CITY OF ALBUQUERQUE

**RE: Montecito Vistas Units 1-4
Grading & Drainage Plan and Report
Stamp Date 8-16-2016 / Hydrology File: D09D005
Revisions Dated 10-13-2016**

Based upon the information provided in your submittal received 10-18-2016, the above-referenced Plan/Report is approved for Preliminary Plat and Site Plan for Subdivision.

**MONTECITO VISTAS**  
**GRADING PLAN**  
**VISTA VIEJA AVENUE**

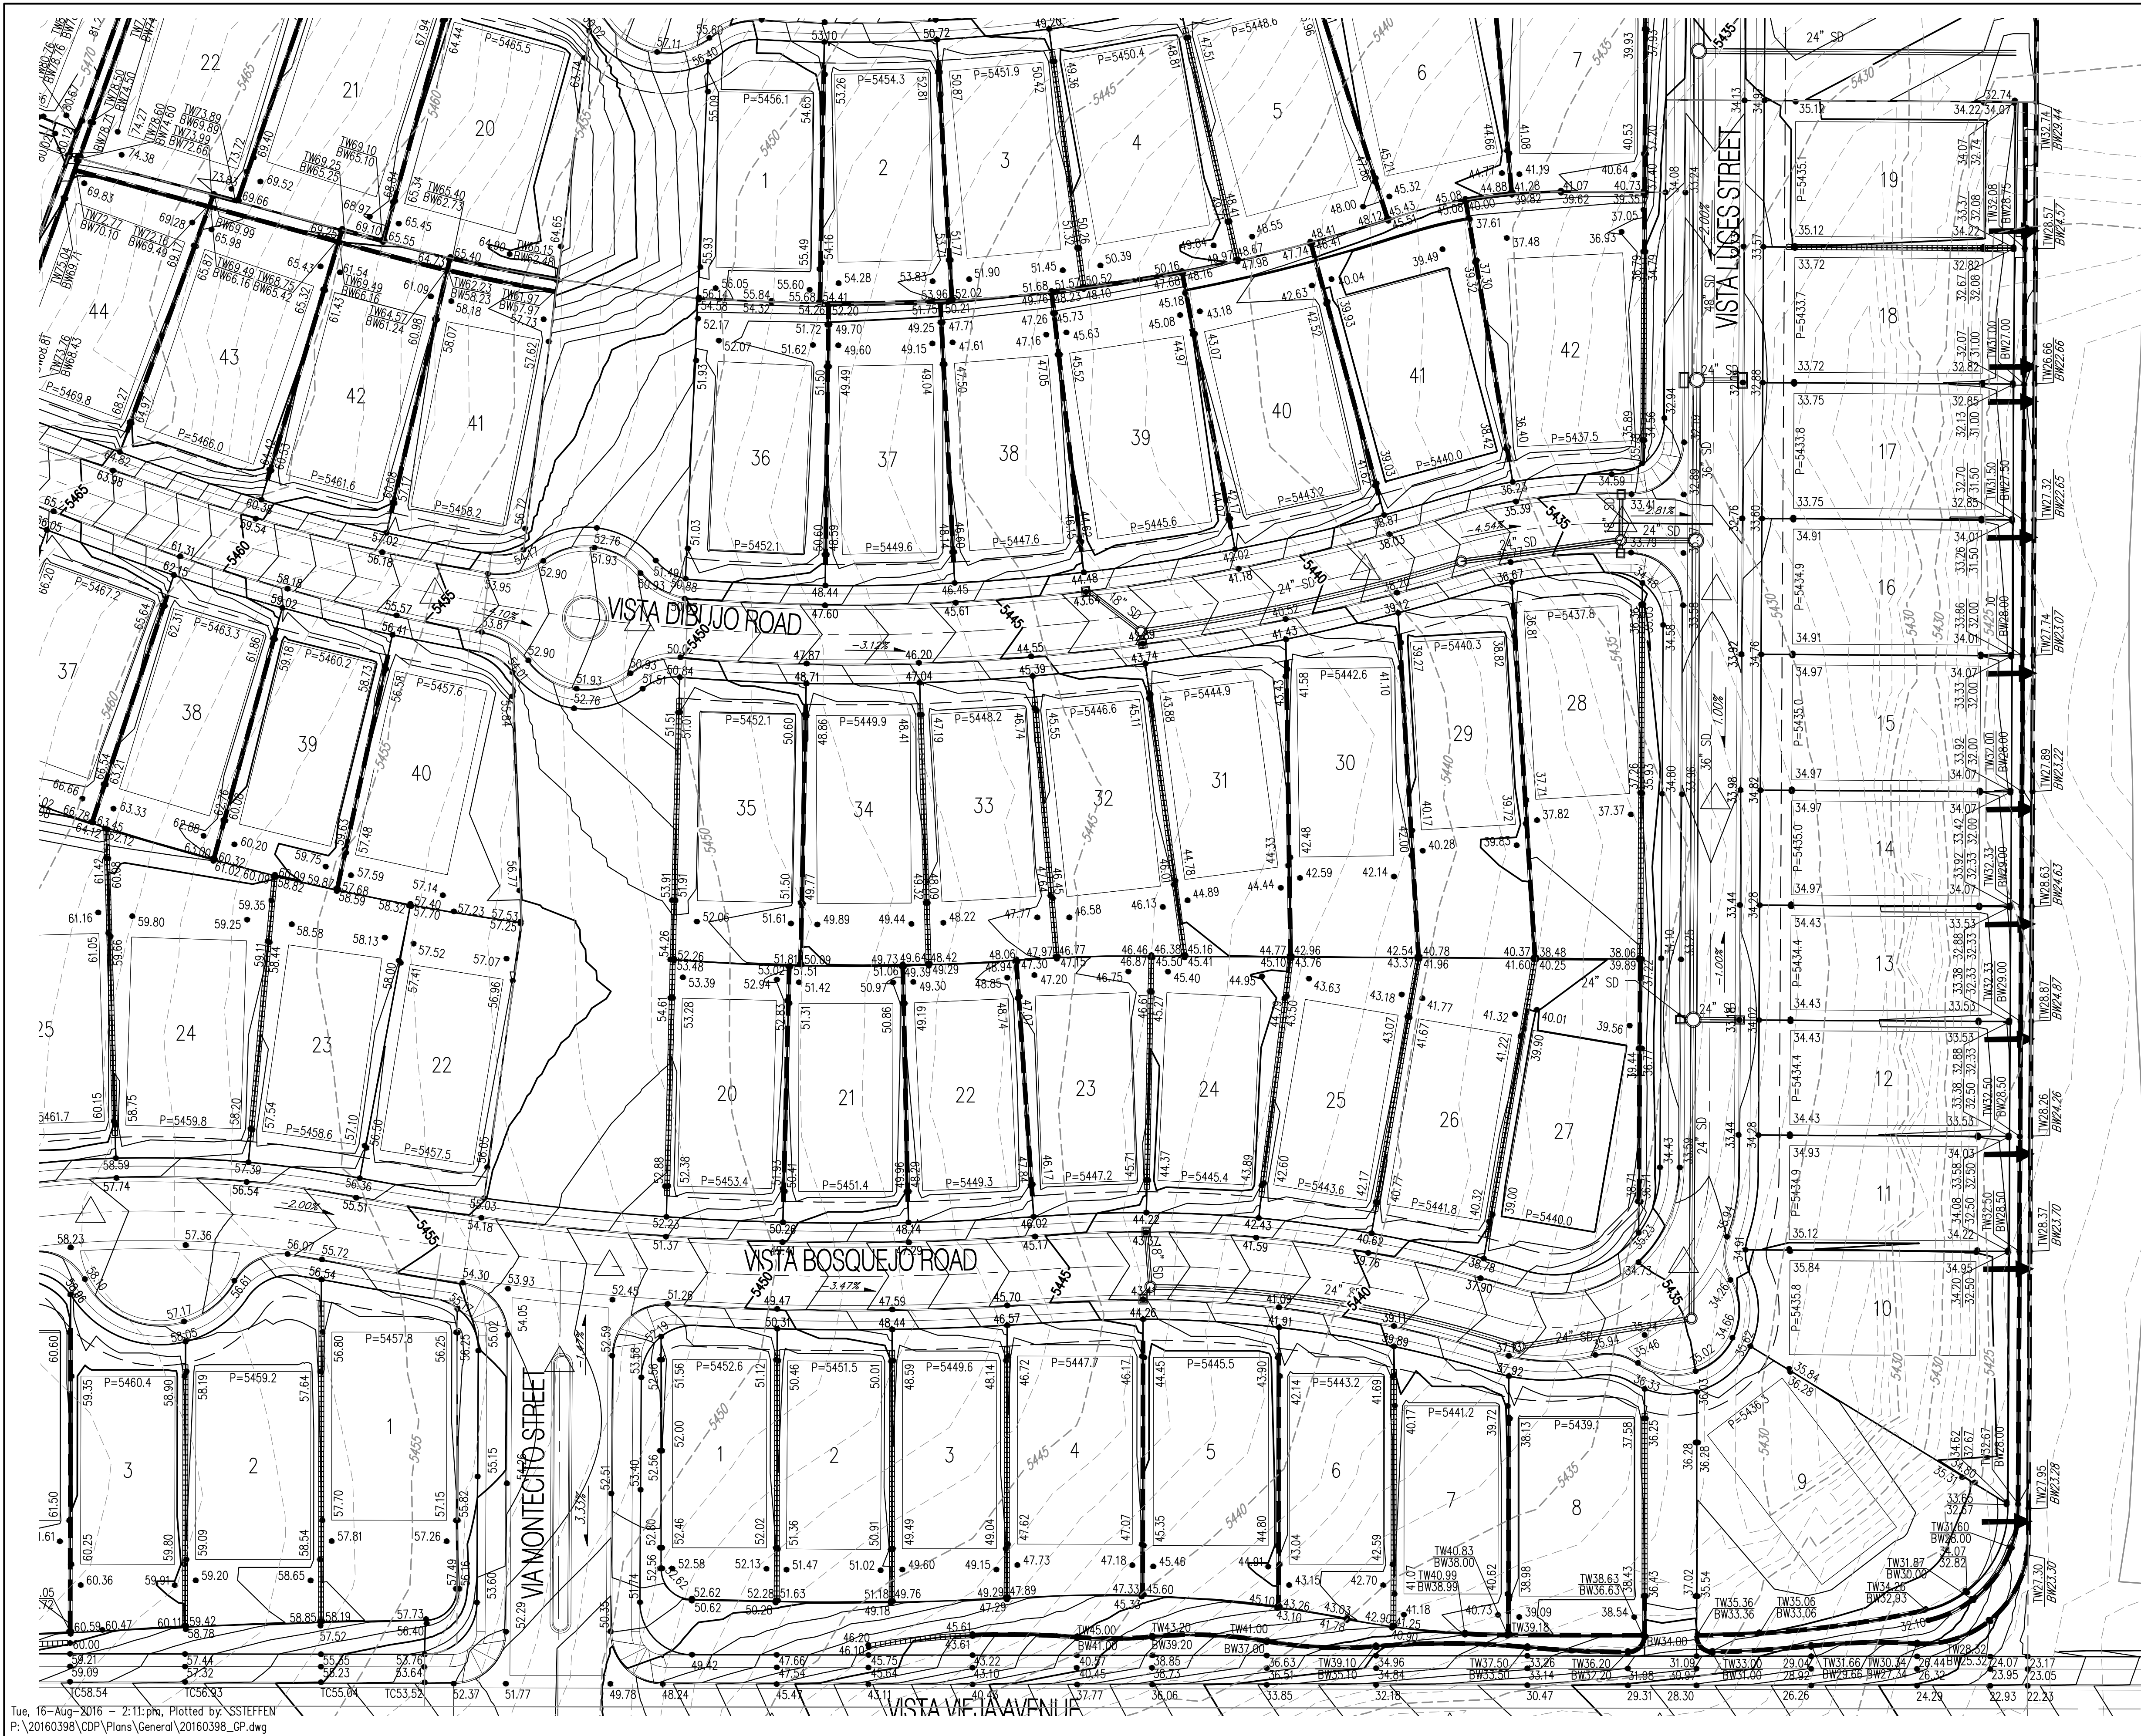
1. An ESC Plan will need to be approved before approval can be given for ESC Grading Permit. An approved ESC Plan and ESC Grading Permit are required prior to any grading on this project.
2. The 60" storm drain outfall will need a designed outlet structure that includes a permanent erosion control/energy dissipation feature. This item will need to be approved by the City Engineer prior to DRC sign off.
3. The 8" PVC that conveys flows from the bermed offsite area (Sheet 4) should be designed with elements to reduce the likelihood of clogging, such as a domed grate stand pipe. Also, please consider piping the flows directly to the swale instead of routing the flows between the retaining walls. This can be addressed prior to DRC sign off, if that element is designed with the work order.
